CONSTRUCTION DOCUMENTS
FALCON MEADOWS AT BENT GRASS FILING NO. 1
FOR
CHALLENGER COMMUNITIES, LLC
BENT GRASS MEADOWS DRIVE & MERIDIAN ROAD
FALCON, CO 80831 - EL PASO COUNTY

INTERSECTION DETAILS

BENT GRASS MEADOWS DR. &amp; ROWENA WAY DETAIL GRADING

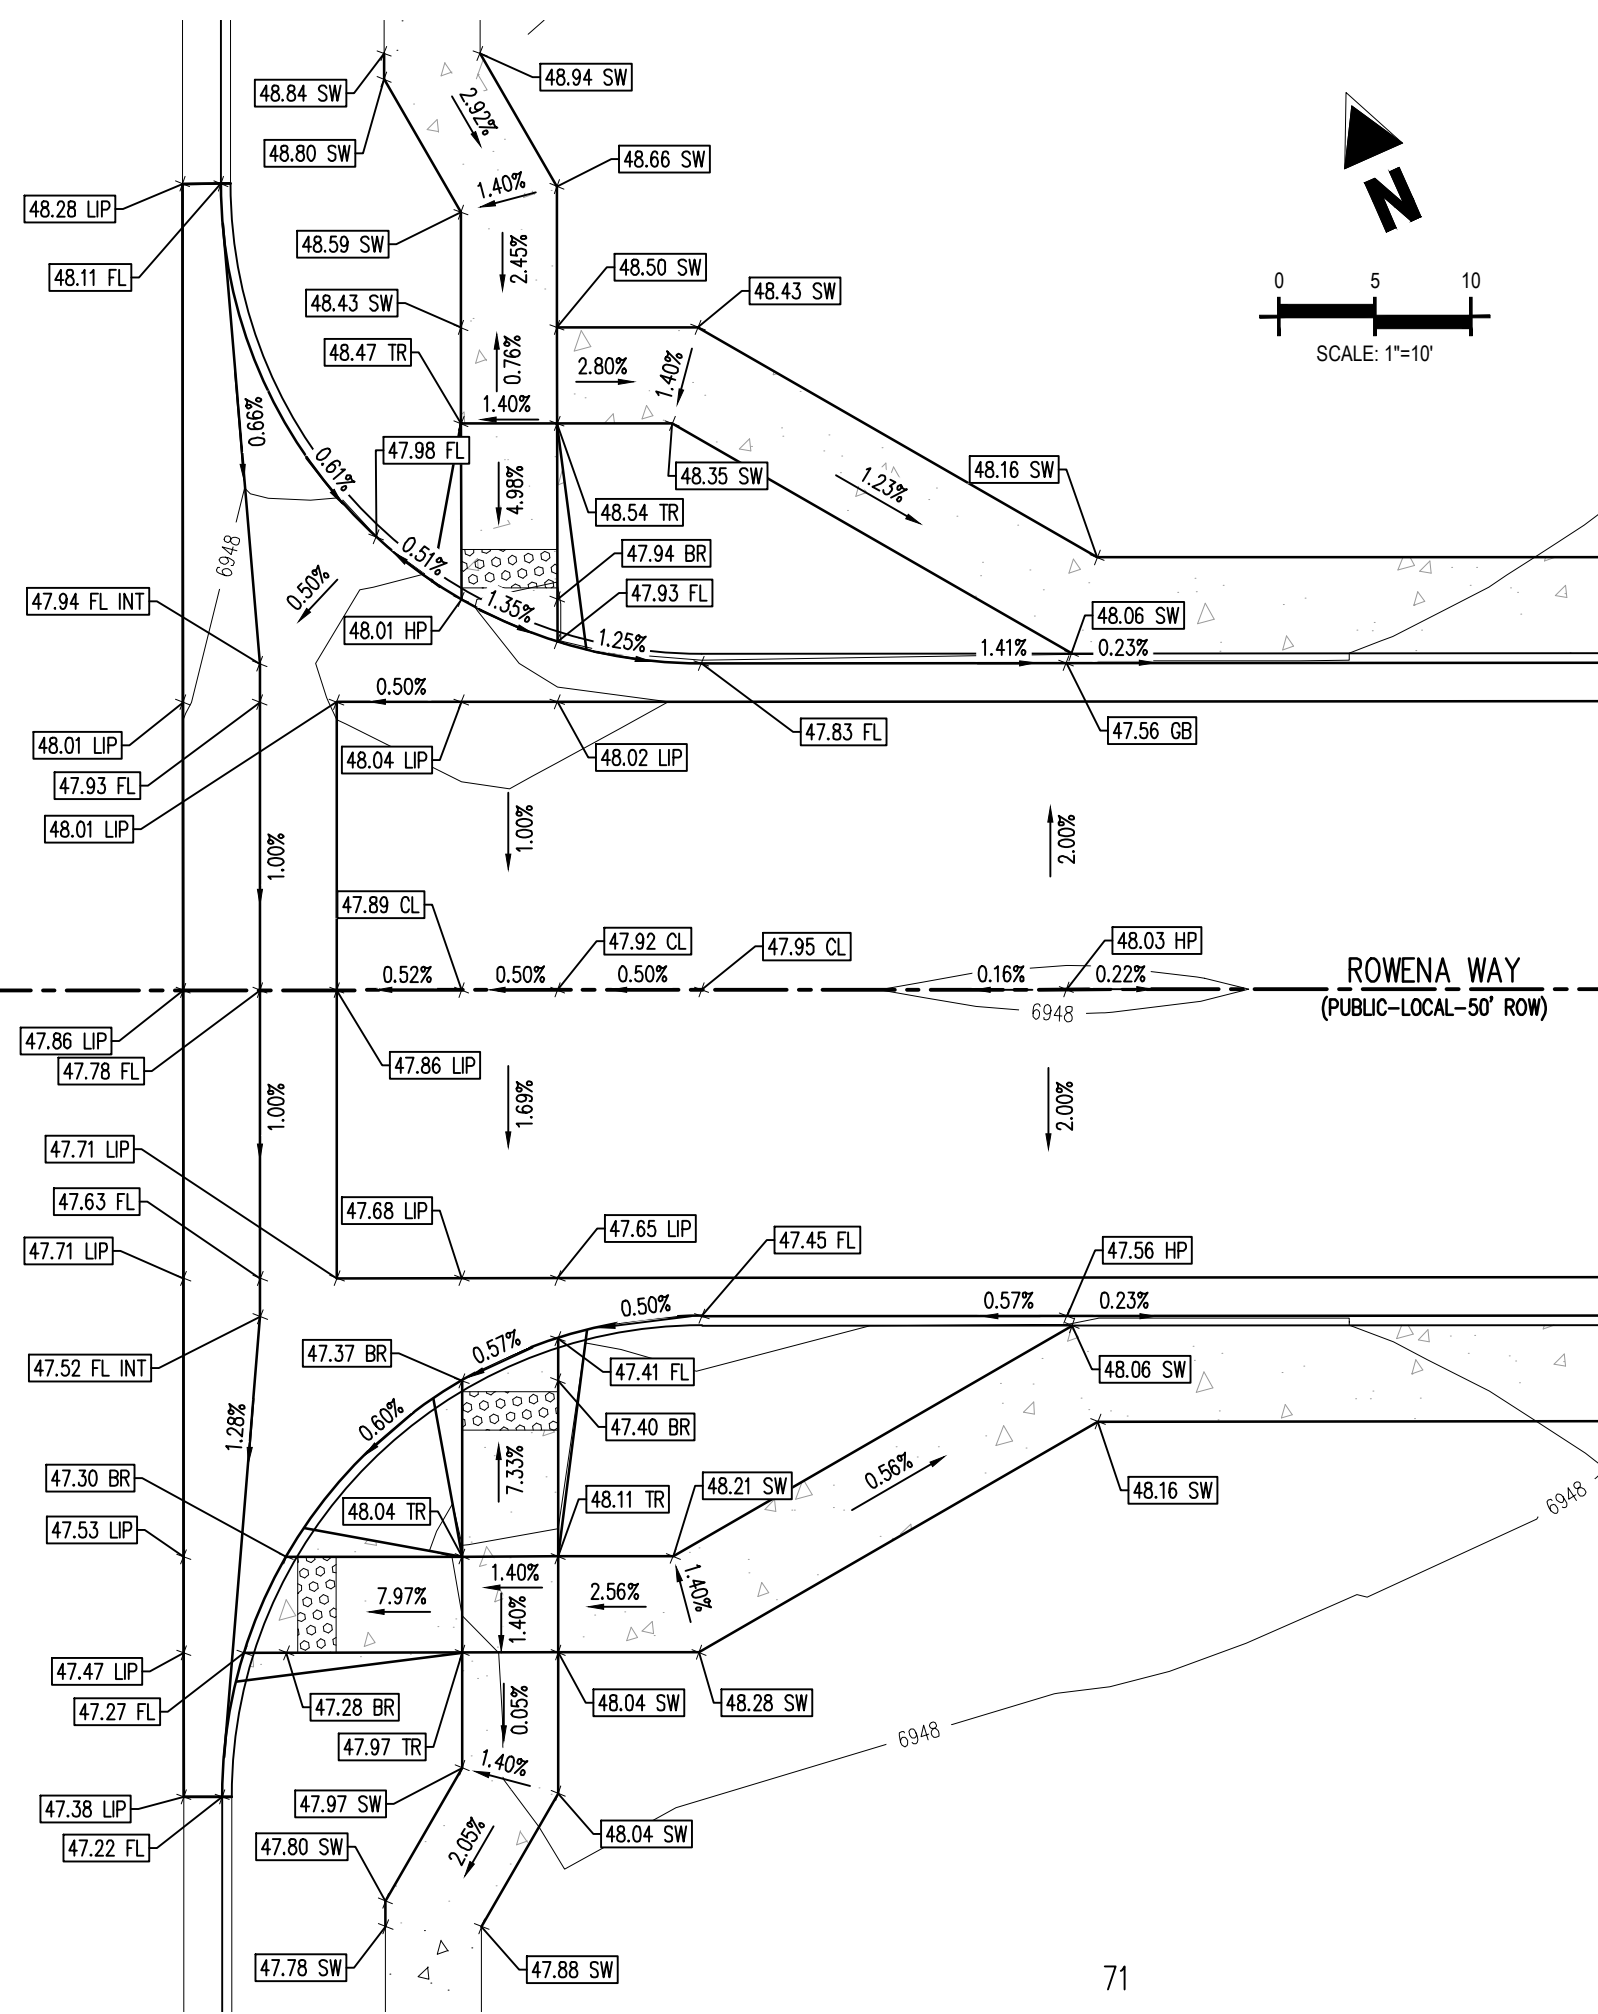
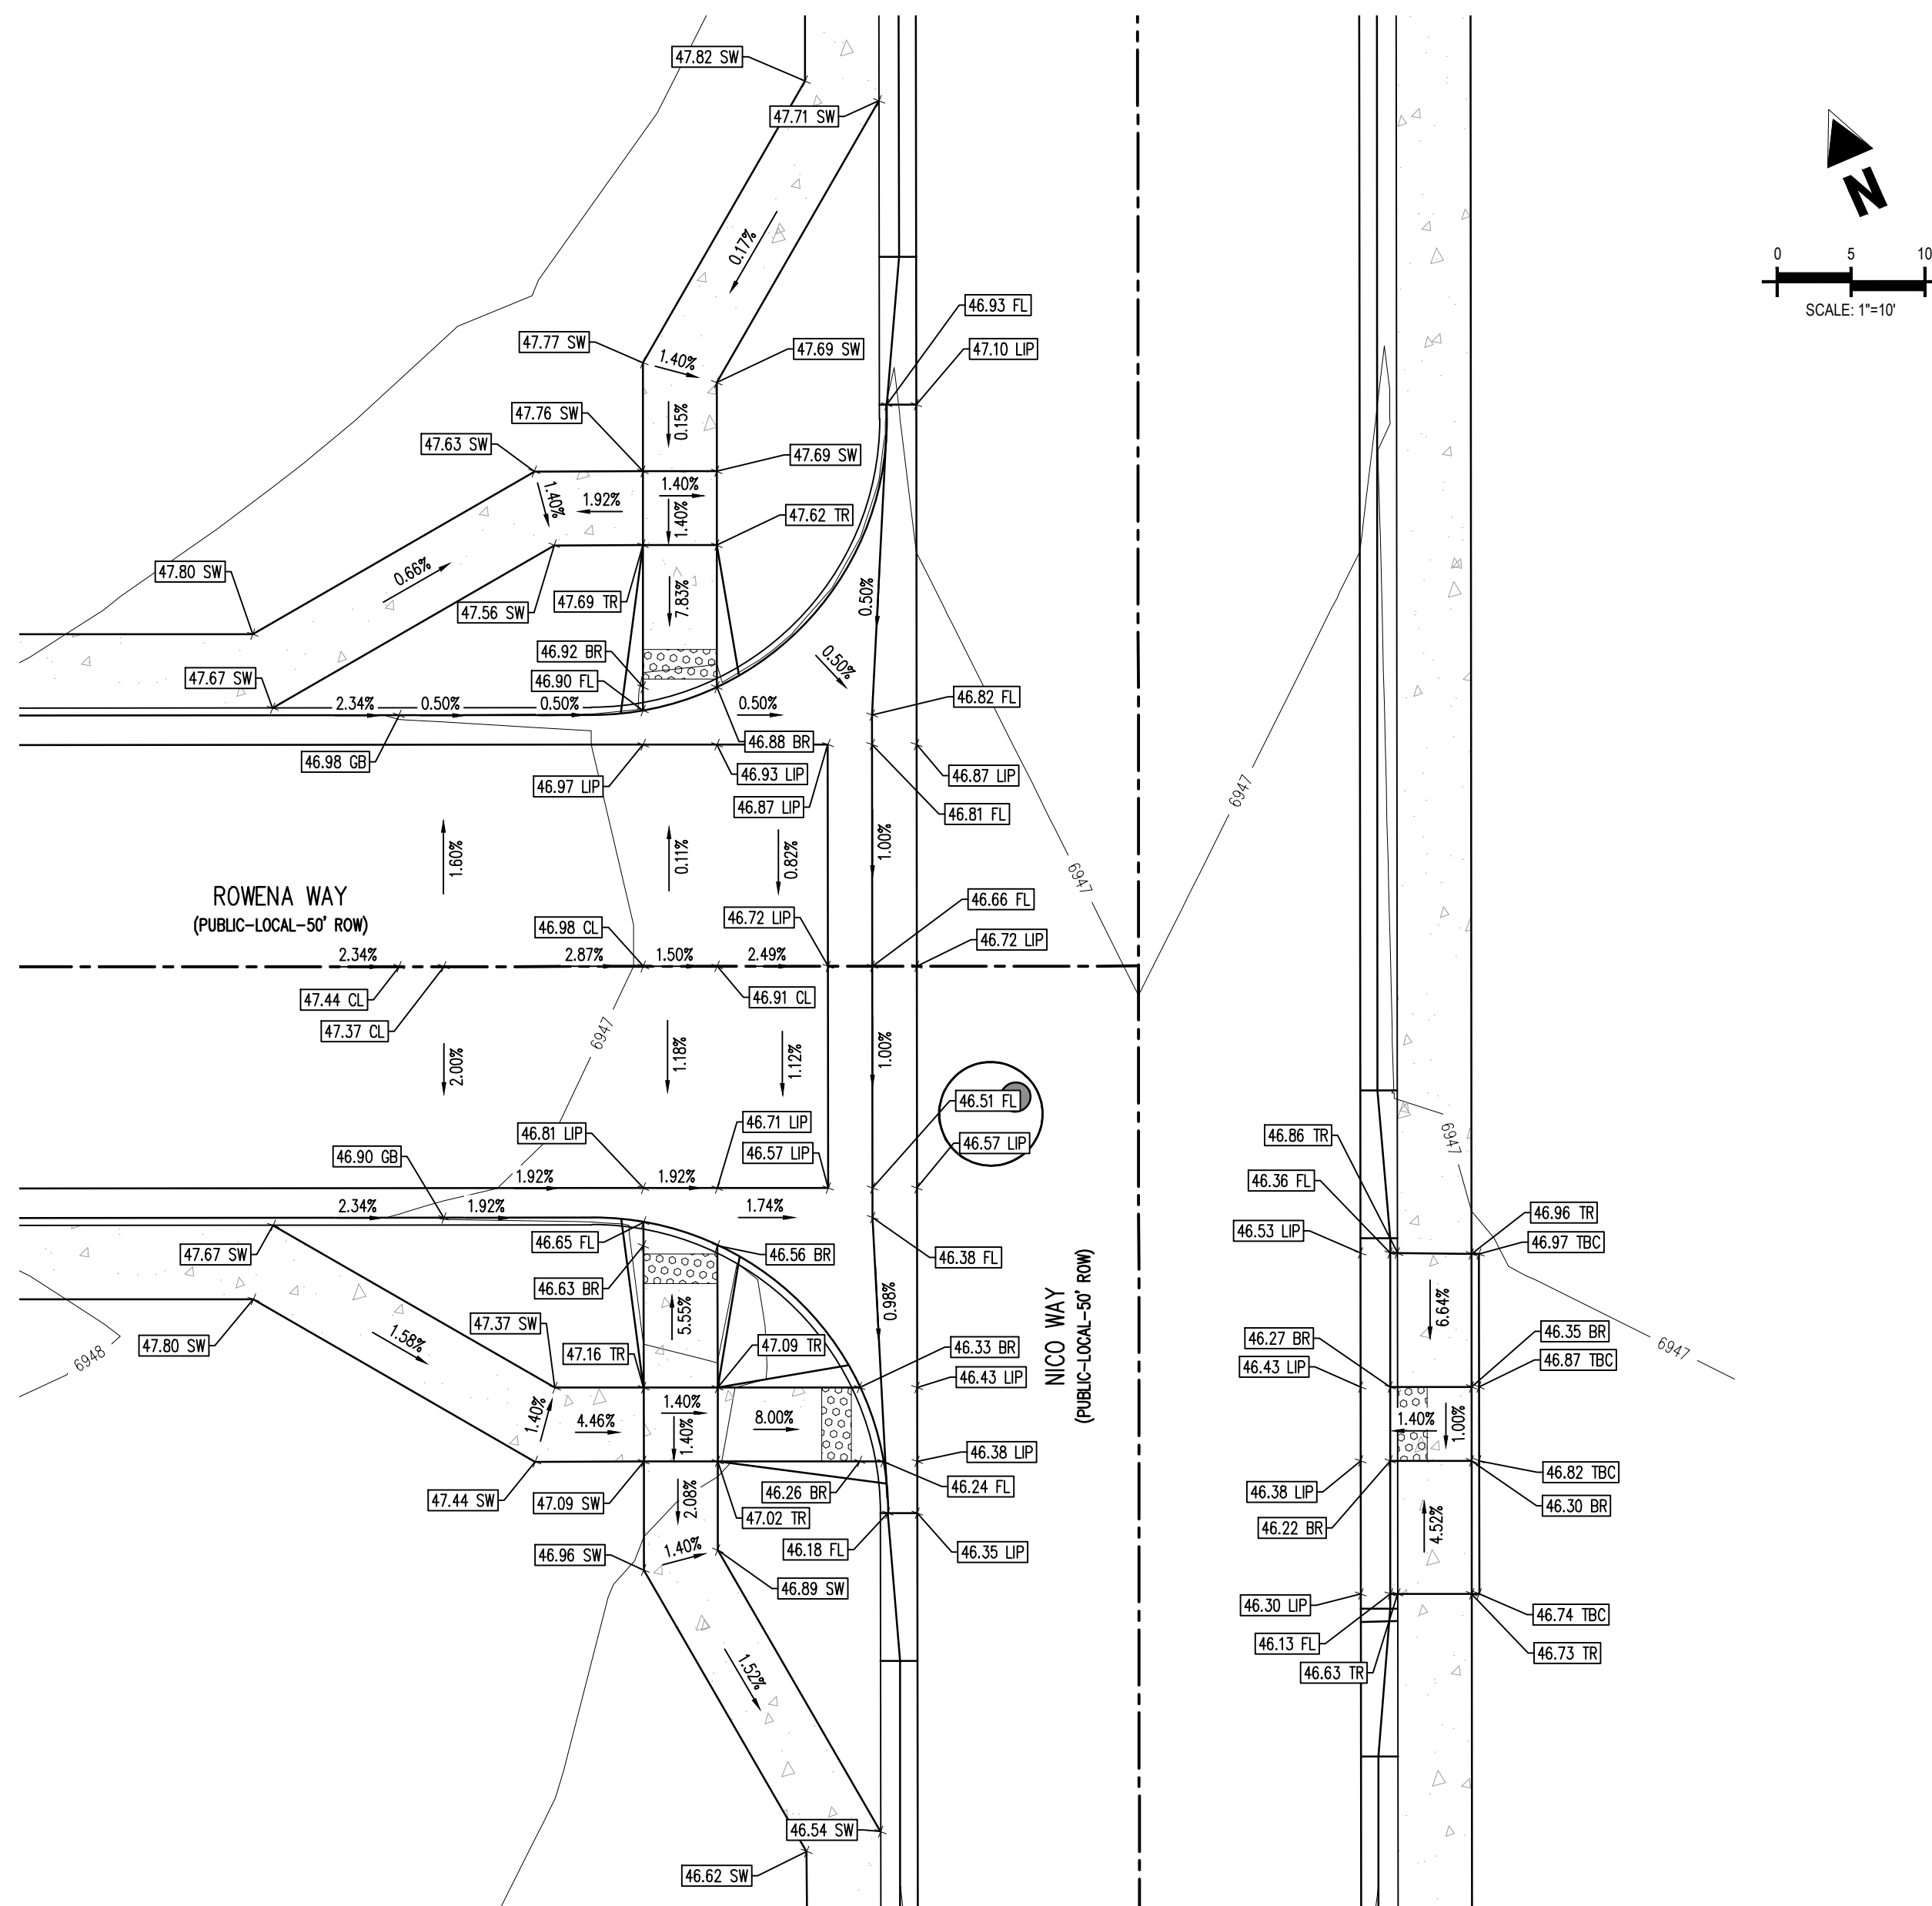
These slopes and cross-slopes still appear to be an issue where birdbaths will result. JEFF, THANKS FOR THE DETAILED REVIEW. I REVISED THE SLOPES HERE AND ALSO FOUND MANY LOW POINTS IN OTHER CROSSPANS. REVISED GRADING ON ALL CROSSPANS (THIS SHEET AND NEXT SHEET)

cross-slopes need to be <1.4 to avoid any slope being over 2% on the landing SLOPES REVISED TO 1.4%

REVISED LOW POINTS AND CROSS SLOPES TO 1.4%
